17th October 2023

**TOWN AND COUNTRY PLANNING ACT 1990 NON-MATERIAL AMENDMENT PLANNING TO APPROVAL
22/01144/F OS Parcel 5700 South West Of Grange Farm, Street Through Little Chesterton,
Chesterton.**

Since the application was approved, the occupier (Siemens Healthcare Ltd) has been refining the proposed plans in order to ensure the built-out scheme meets their detailed operational requirements. This has necessitated a number of minor changes to the external and internal appearance of the building. The table below sets out the changes that are required.

Drawing Name: Roof Plan

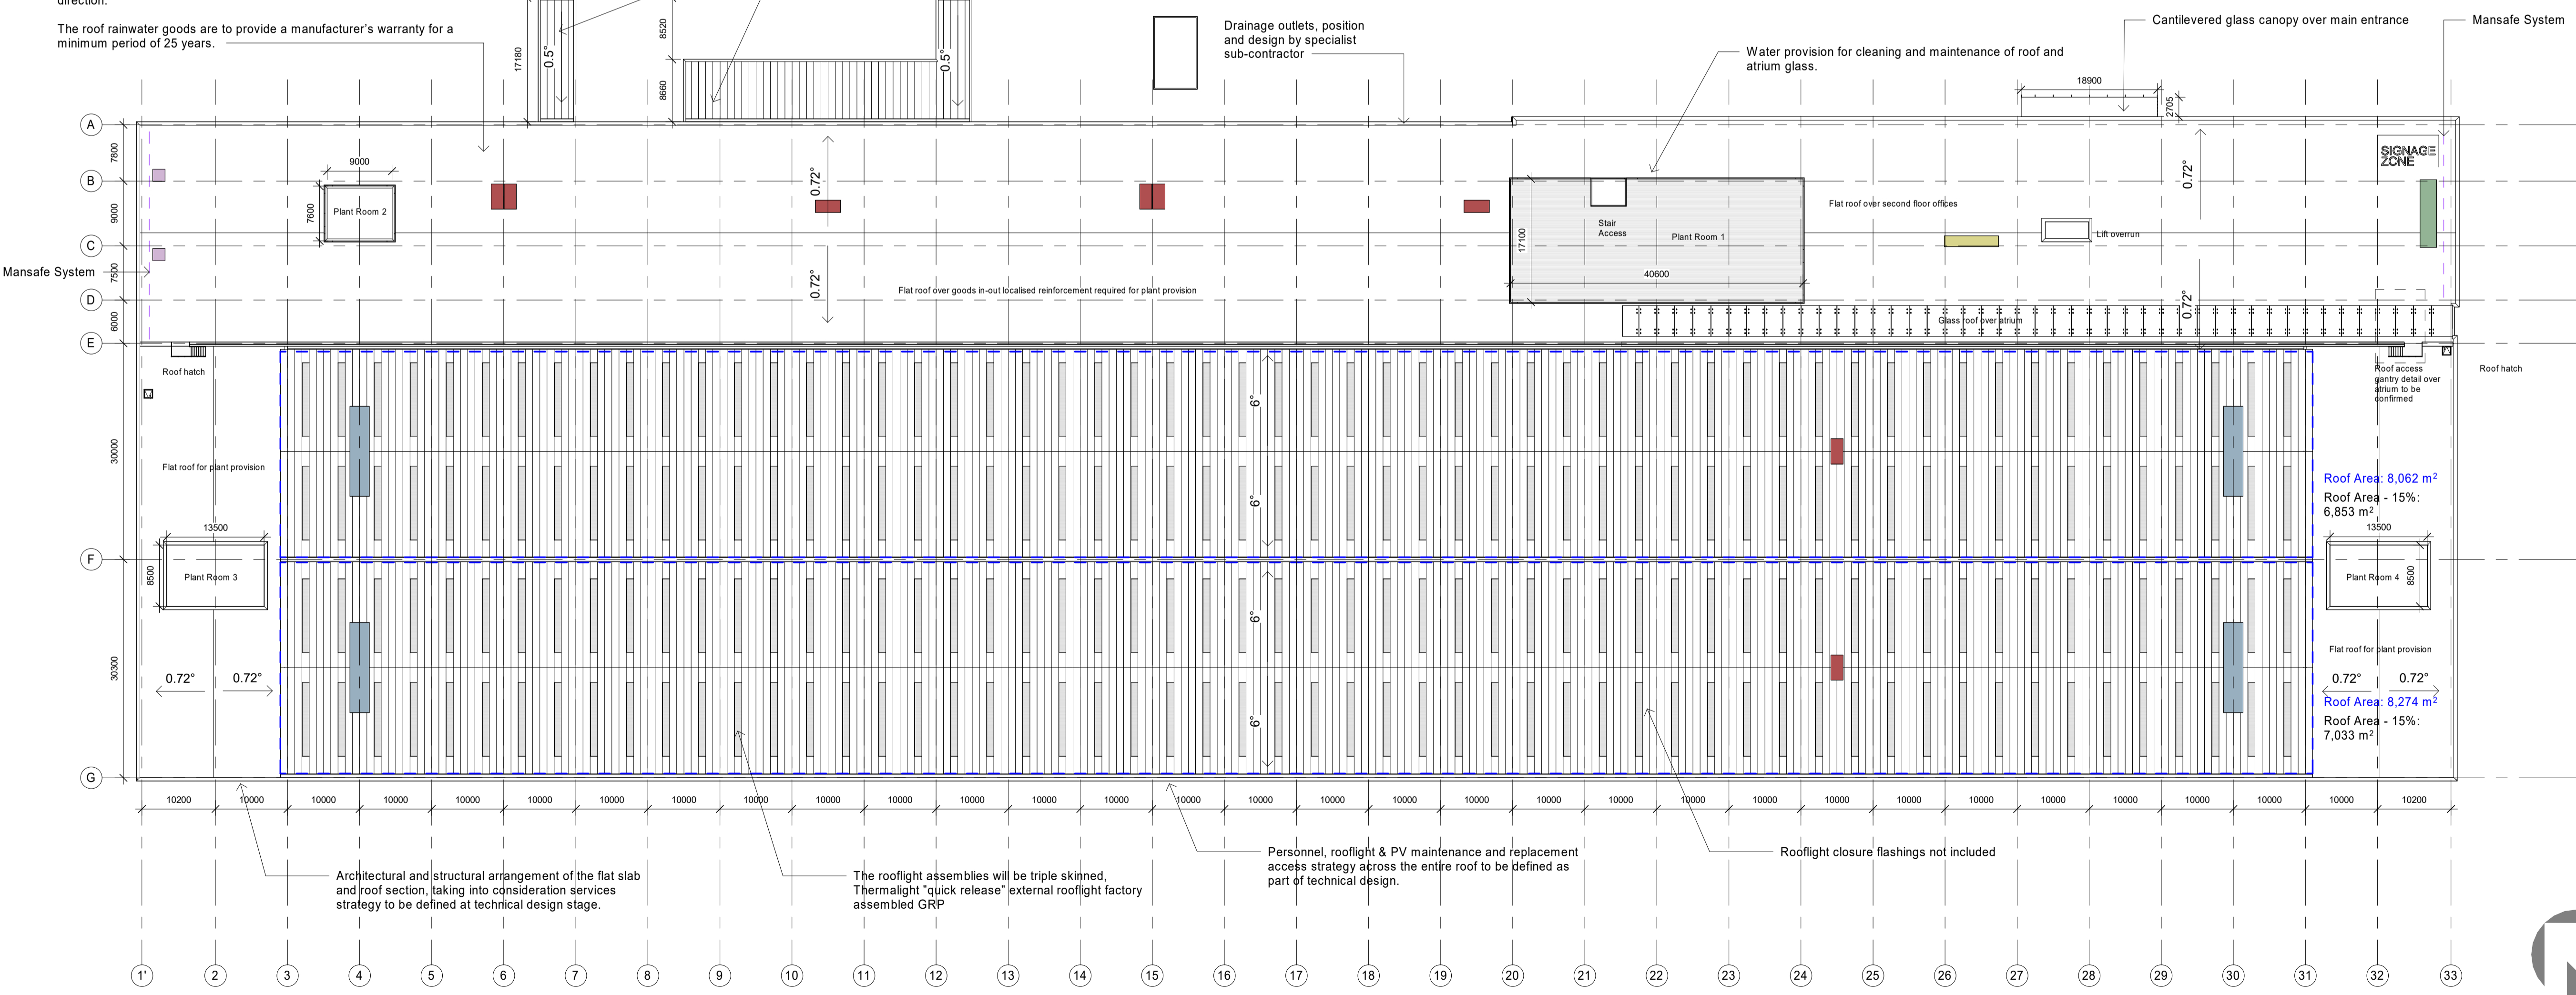
Rationalisation of services/plant equipment on the roof.	Siemens have been reviewing the approved design and operational performance of the production facility and how to maximise operational floorspace. Plant and services extrusions have been concentrated into focused areas, and where these protrude from the roof they will be visually enclosed in a reduced number of plant rooms and service kennels to rationalise operational requirements and minimise visual clutter. The maximum height of the plant rooms does not exceed the maximum height of the 16.15m fall protection railing currently approved. There is however a lift overrun measuring 3.9m x 4.9m in size that has an overall height of 17.40m.	Phase 1 Roof Plan 13-222-SGP-ZZ-ZZ-DR-A-131109 Rev G.	Roof Plan 13-222-SGP-01-ZZ-DR-A-201155 P01.

The maximum approved height of the building is the fall protection railing at 16.15m (see paragraph 3.4 of Committee Report / section 8.1.7 of the approved design and access statement). The rationalisation of services/plant equipment on the roof, reducing visual clutter, has maintained them within the approved 16.15m fall protection railing height, with the exception of a lift overrun measuring 3.9m x 4.9m in size that has an overall height of 17.40m.

Drawing Name:	Enlarged Welfare Core
Drawing Stage:	CONSTRUCTION
Status:	53
SGP File Ref:	000002
SGP Project No.:	13-222
Date:	06/09/22
Drawn:	YJM
Checked:	MMS
Scale:	1:50
Rev:	P01
Drawing Number:	13-222-SGP-01-ZZ-DR-A-201153
Project Code:	Originator
Volume Label:	Type
Size:	Number

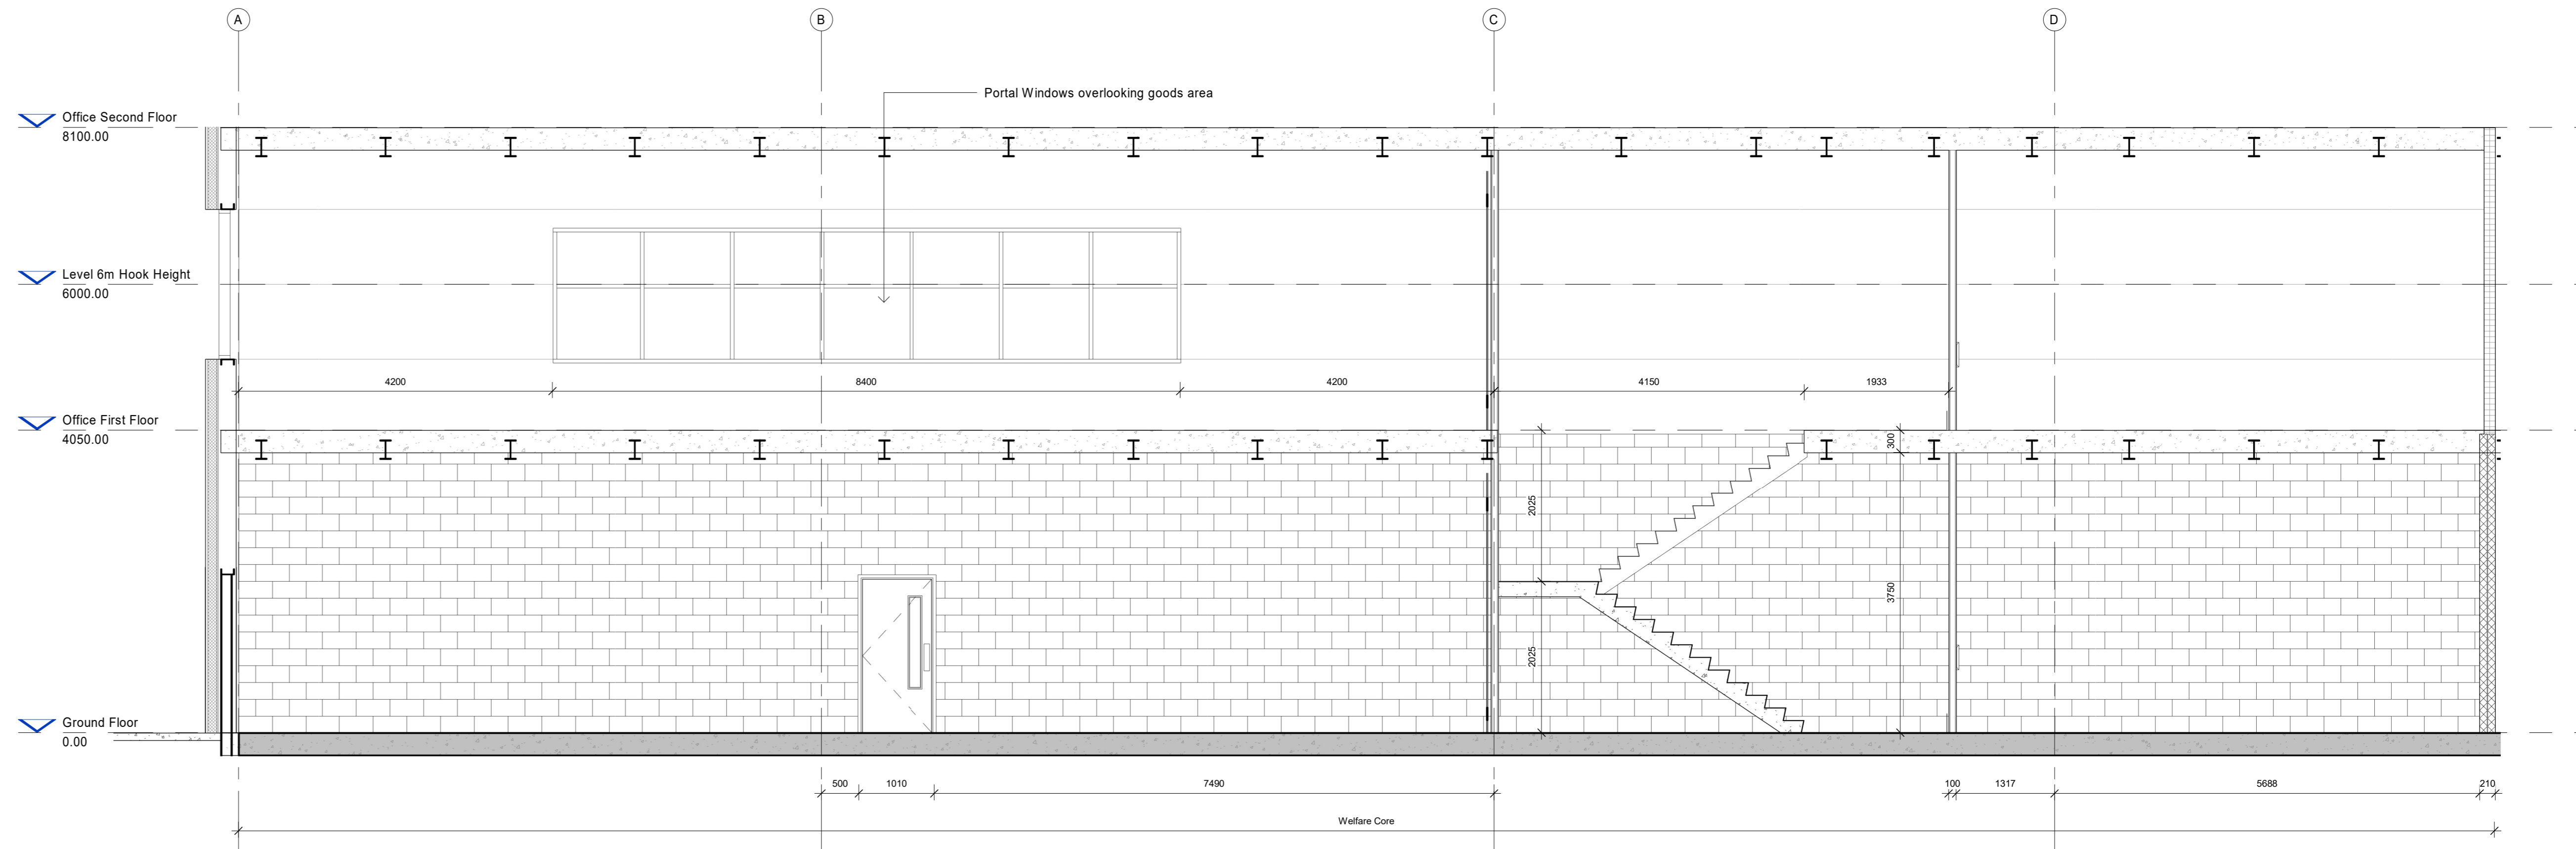
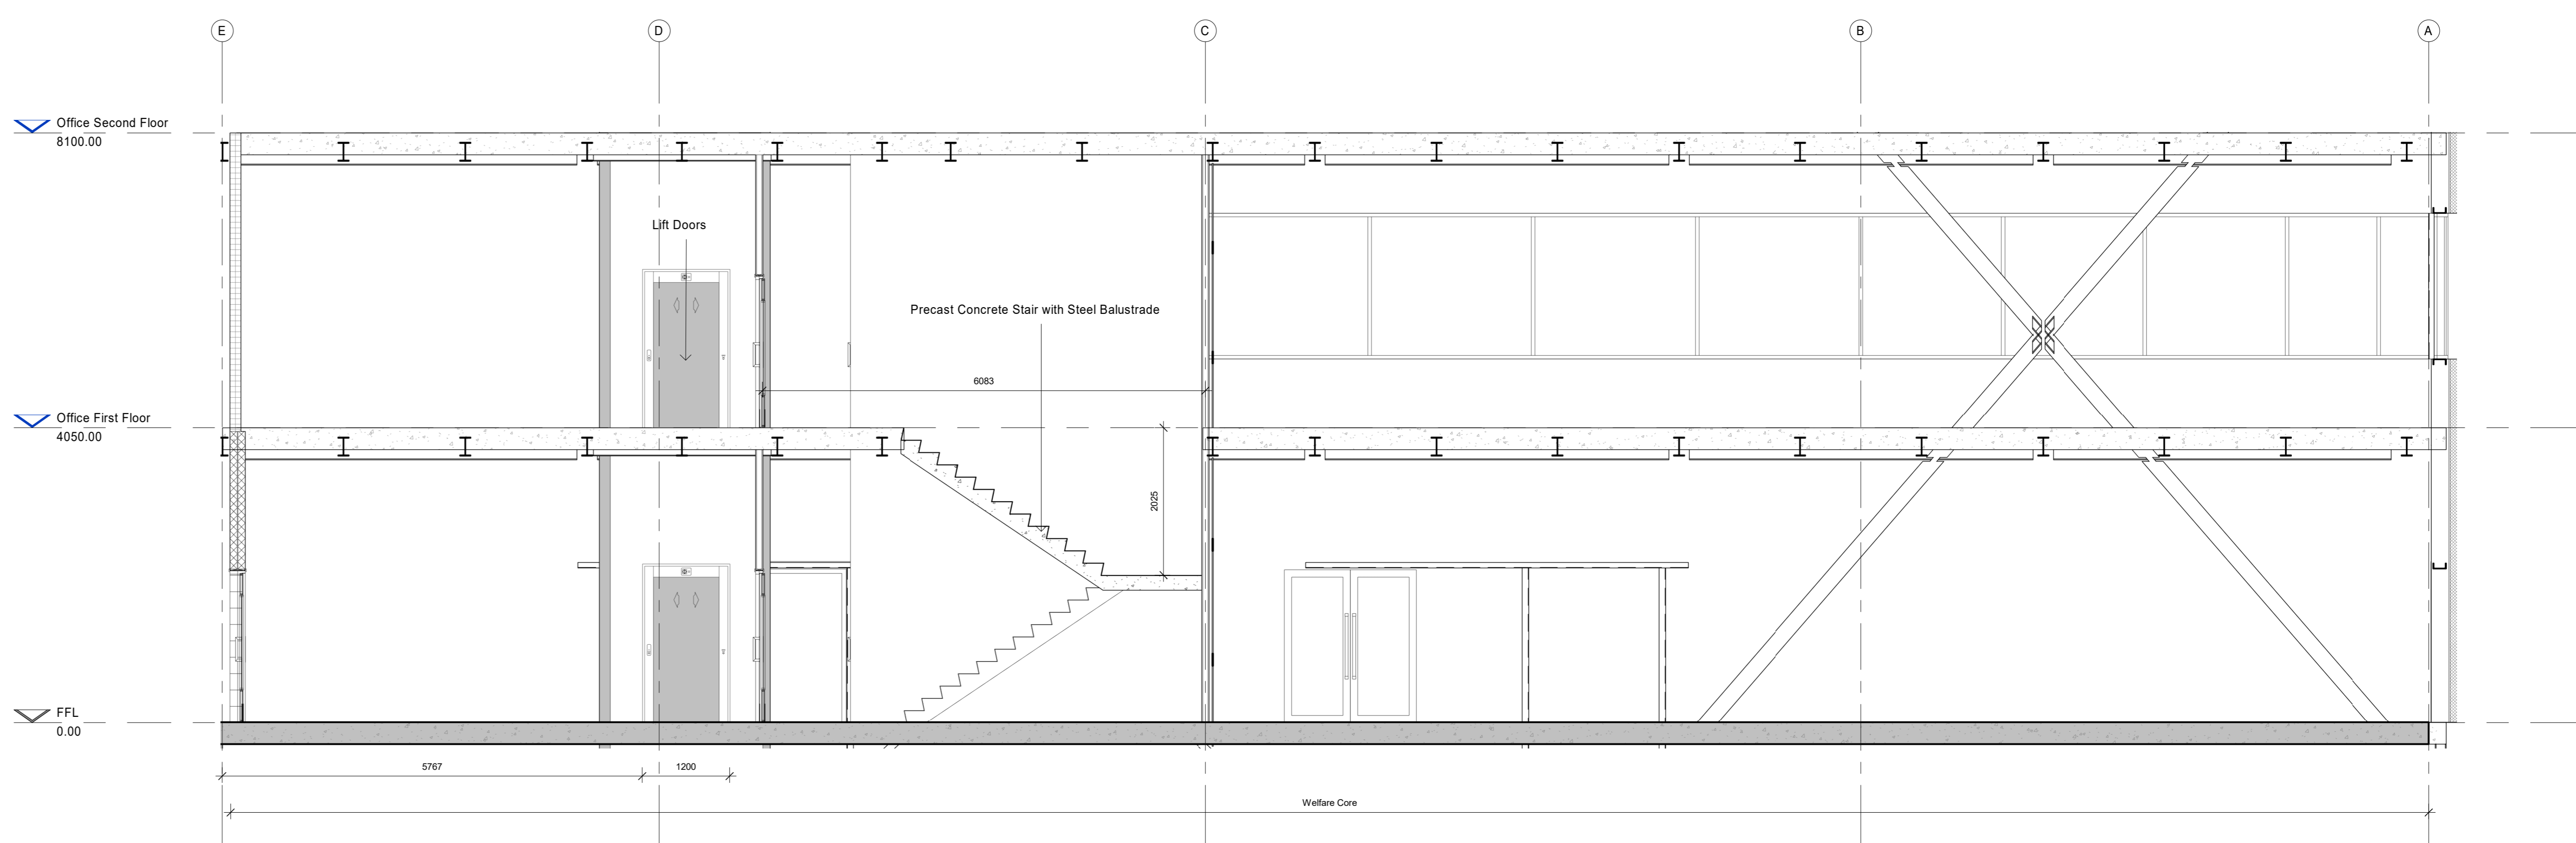
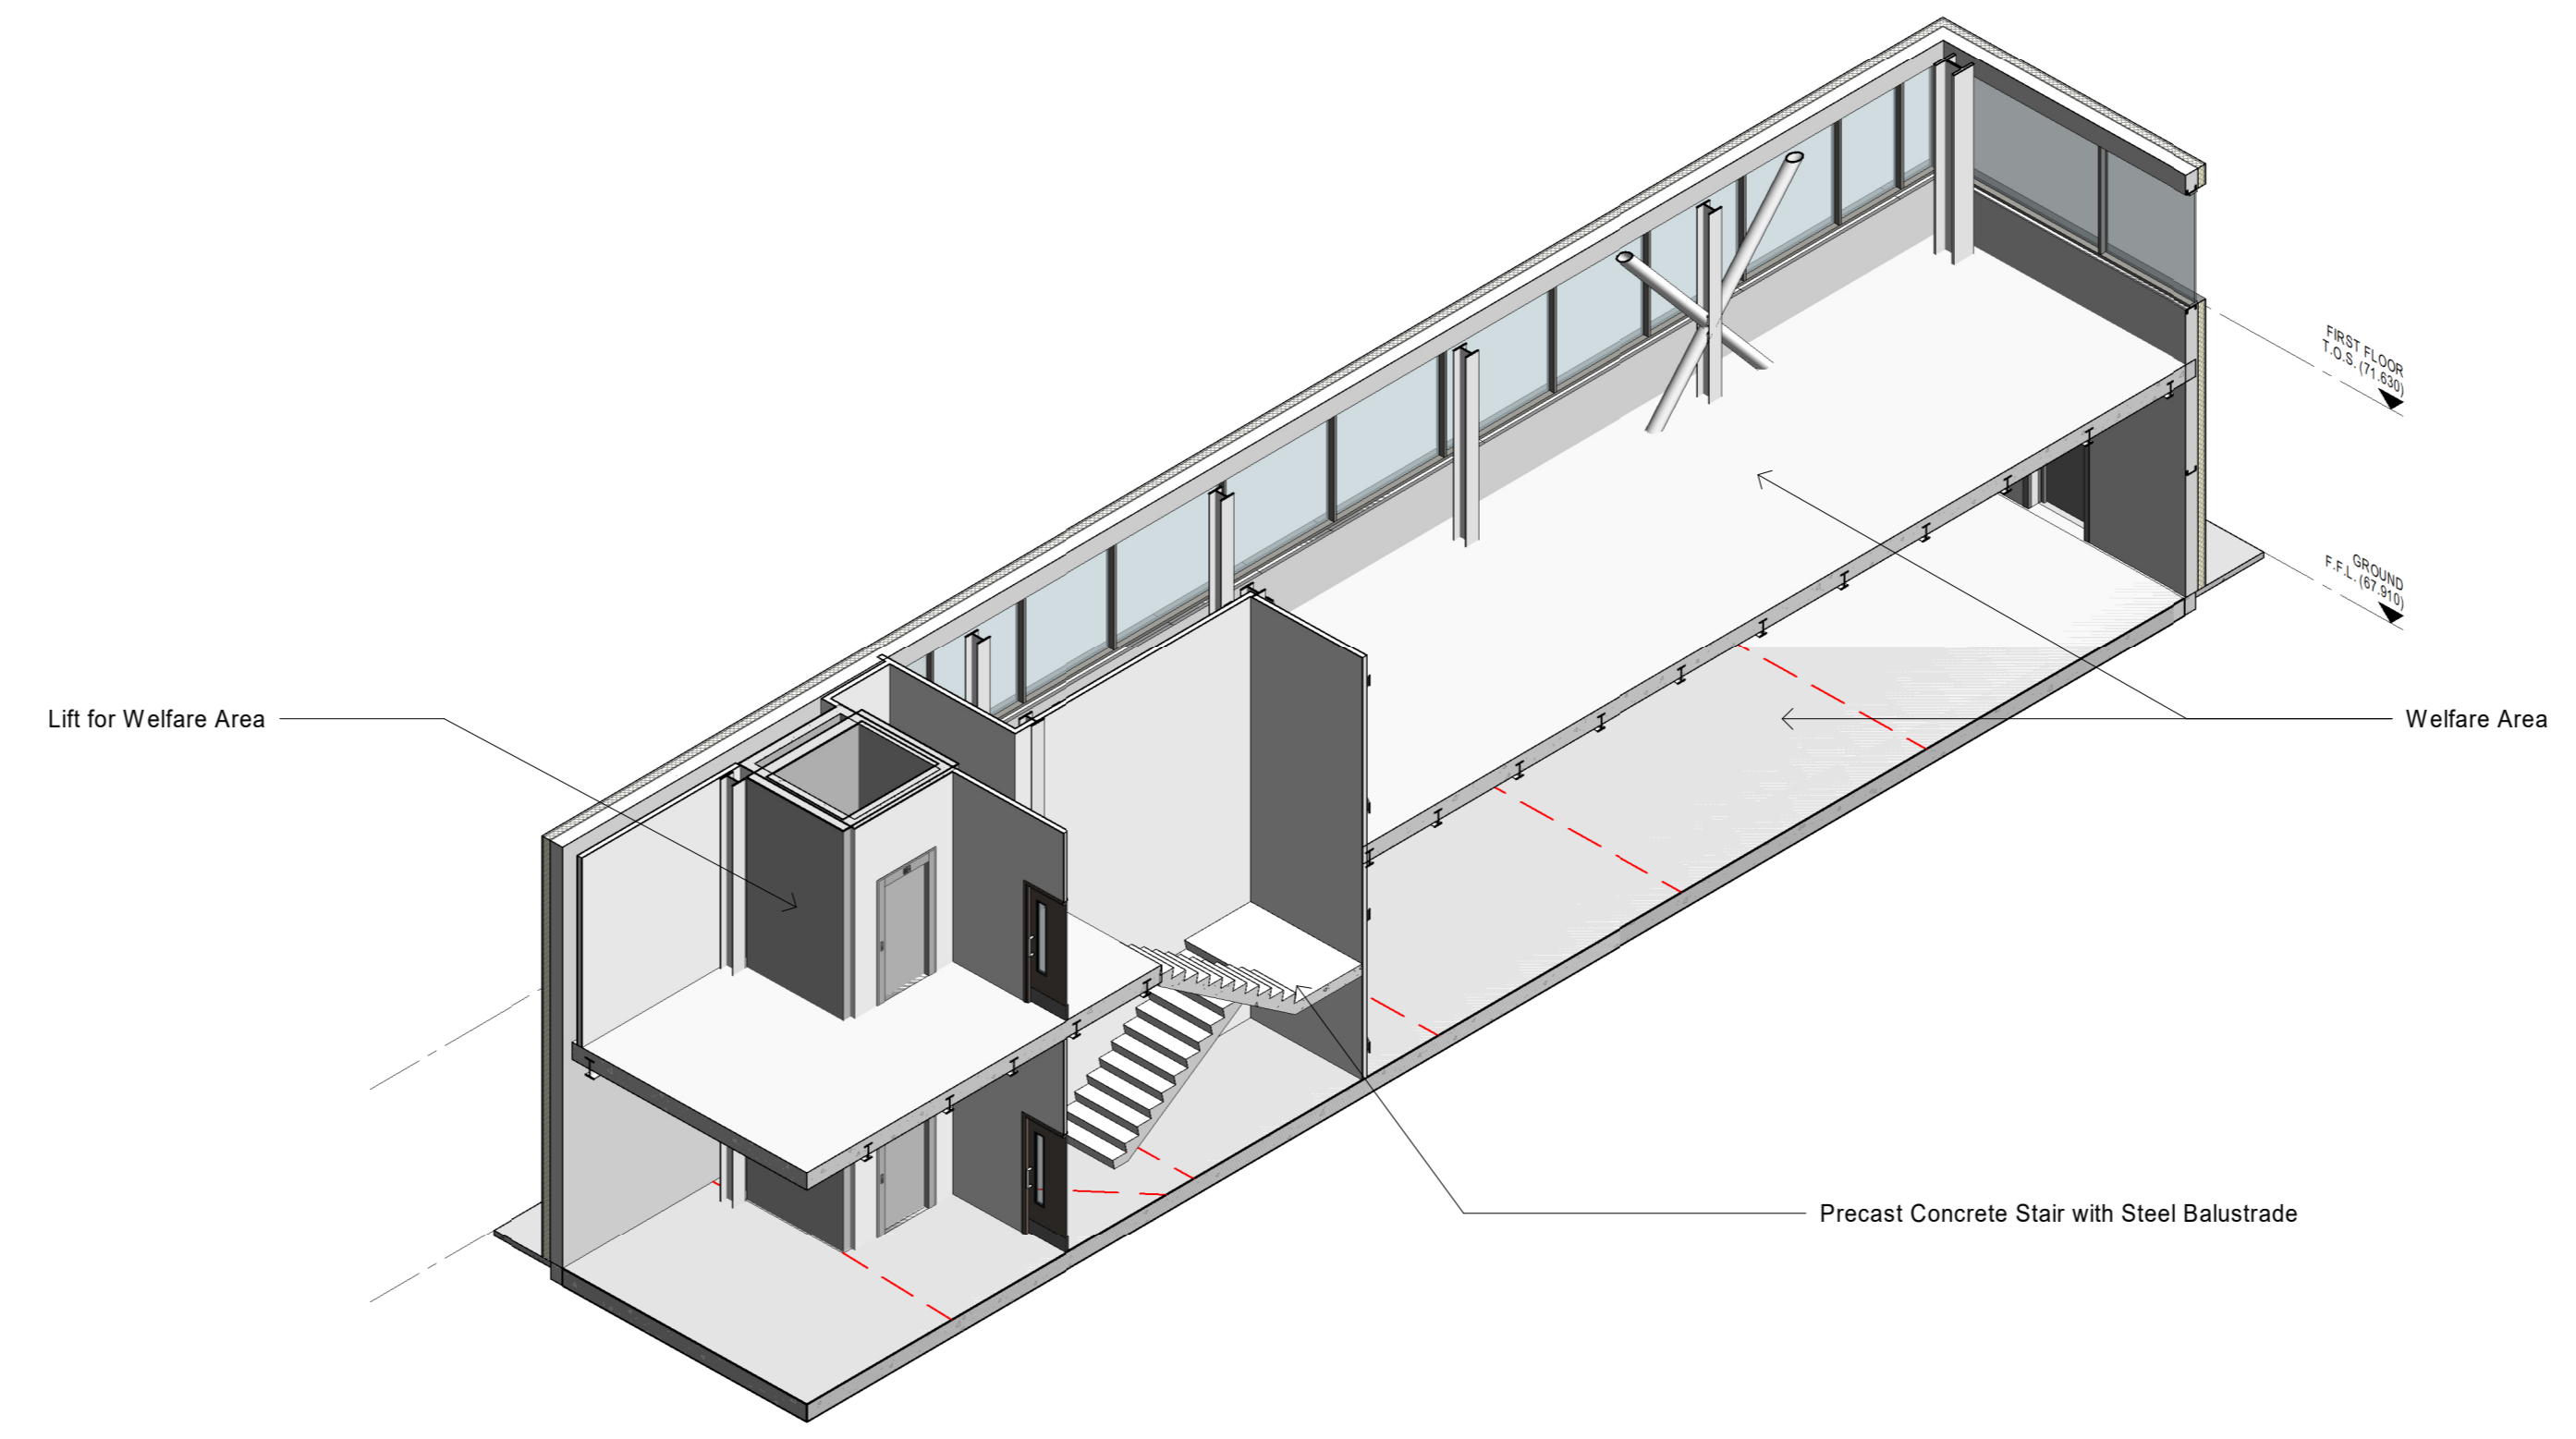
Description of change	Further information on proposed change.	Approved Plan	Amended Plan
Internal alterations within the production hall to construct a two-storey welfare block with lift to replace the need for the approved external Facilities Management Building.	The facilities management building as shown on the approved site layout plan is no longer proposed to be built out, with the relevant provision now proposed to be incorporated within the main building. This change will not result in an increase in overall sq ft, and all other proposed changes will be internal to the main production facility building.	Phase 1 Production Area Layout 13-222-01-SGP-ZZ-ZZ-DR-A-131105 Rev F.	Production Area Layout 13-222-SGP-400-PA-D-A-121151 Rev P01. Enlarged Welfare Core 13-222-SGP-01-ZZ-DR-A-201153 Rev P01. Site Plan 13-222-01-SGP-01-ZZ-DR-A-201051-P02 Site Plan 13-222-01-SGP-01-ZZ-DR-A-201051 Rev P03.
